Werner Steyer  
iBUG Chairman  
68 Lake Entrance Rd  
Oak Flats 2529  
16 November 2015

## Illawarra BUG feedback on the Albion Park Rail Bypass Environmental Impact statement

# Map 3 - Southern Interchange

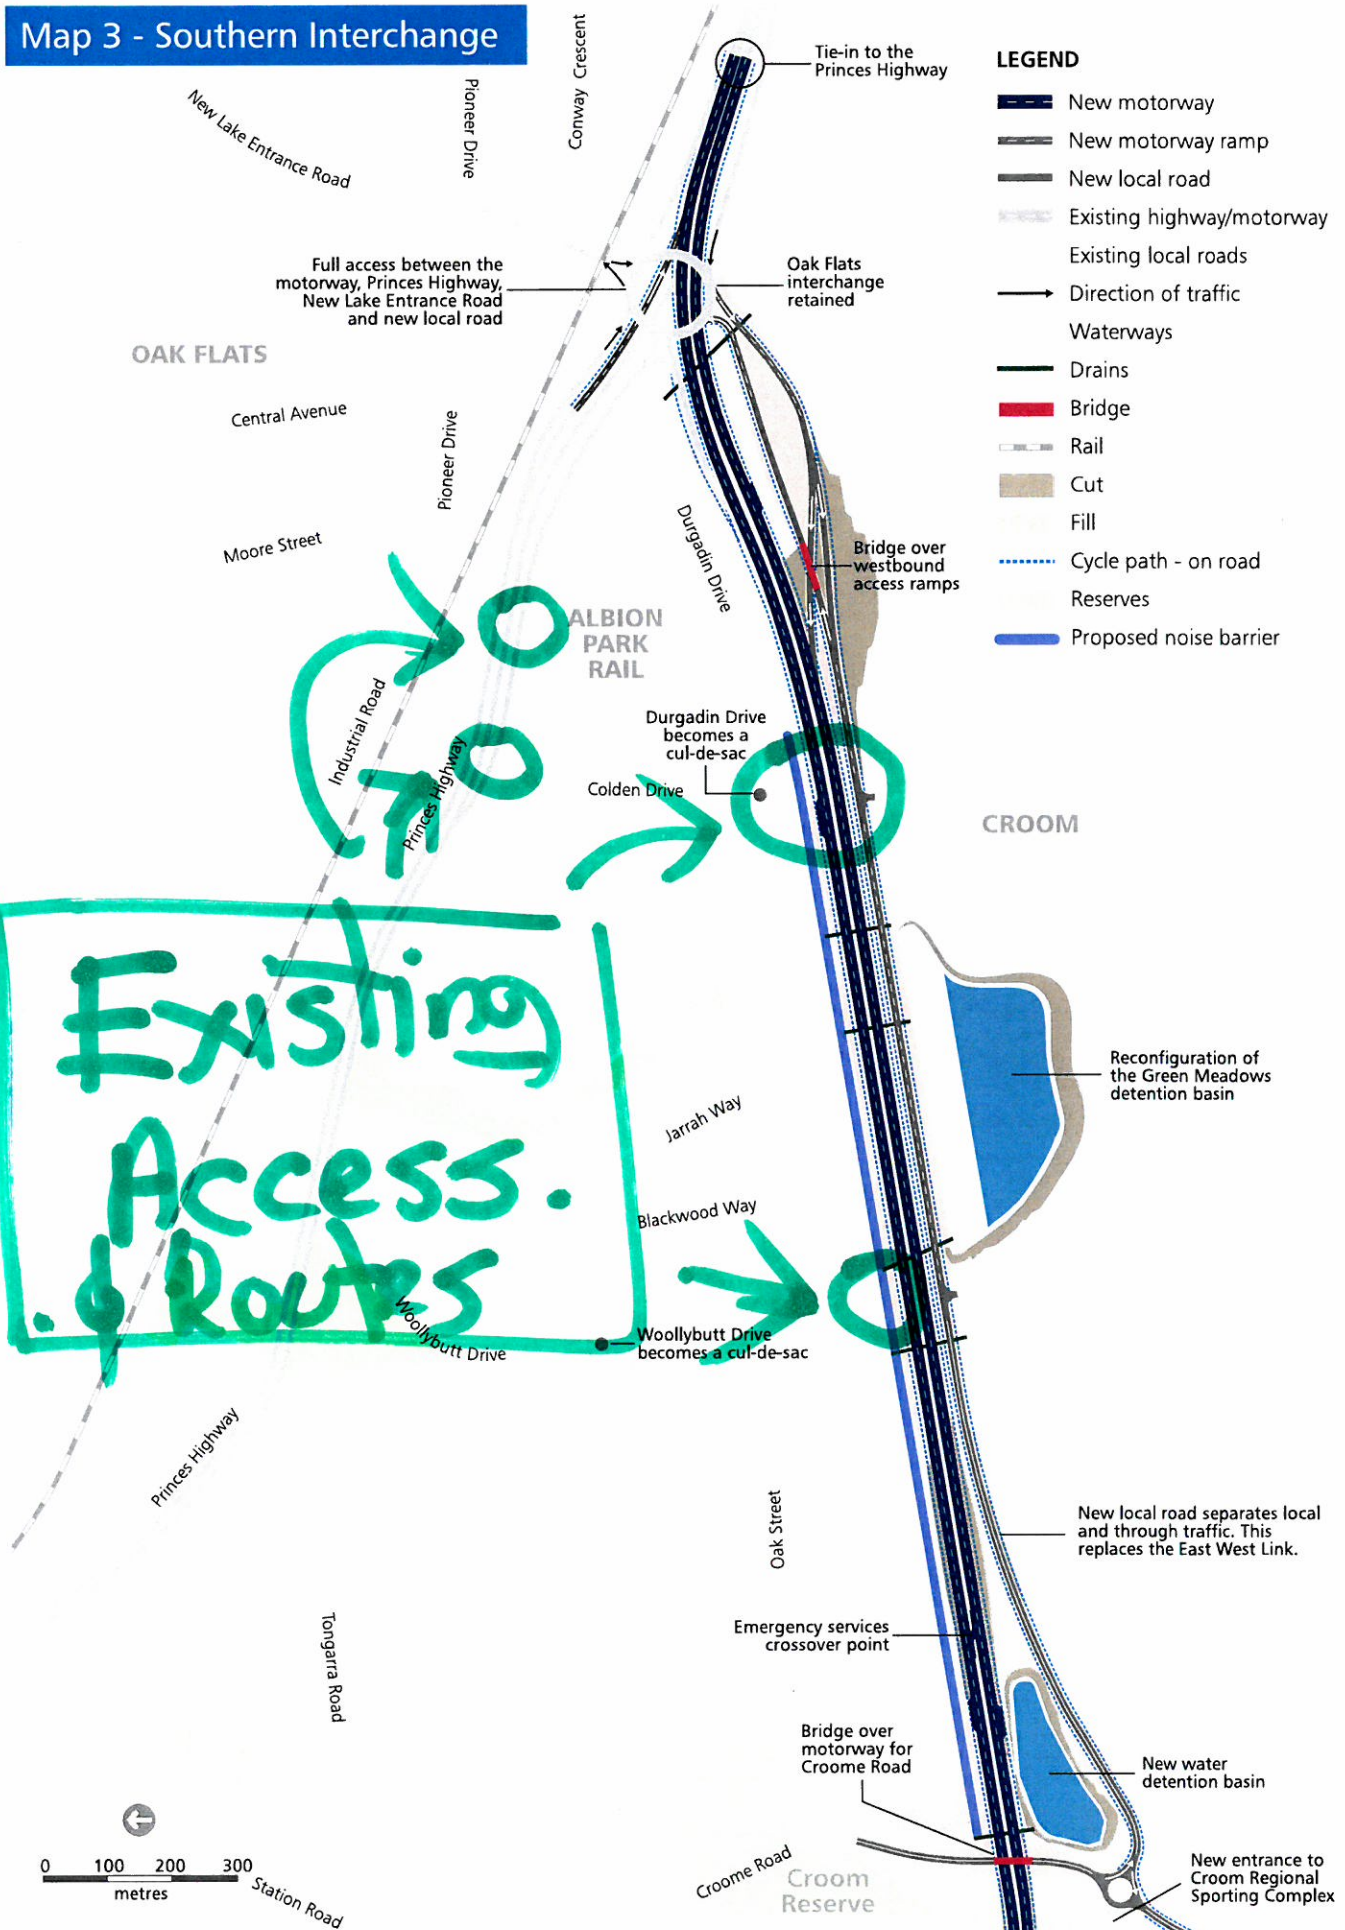
Our only outstanding concern is the lack of a separated bicycle route or shared path between Croom Road and Durgadin Drive as the existing link from the East West Link Road will be severed by the new Bypass, forcing cyclists to use the hazardous New Lake Entrance Road interchange.

Our proposal to provide a bicycle shared path along the north side of the sound barrier as seen on the marked-up map 3 would provide a safe route to encourage more people to cycle, without using the motorway. This route would add a substantial link as it would provide a safe route between the exiting cycling infrastructure in Croom Reserve and Oak Flats when linked with back streets, the signalised intersection on the Princes Highway and the pedestrian rail crossing.
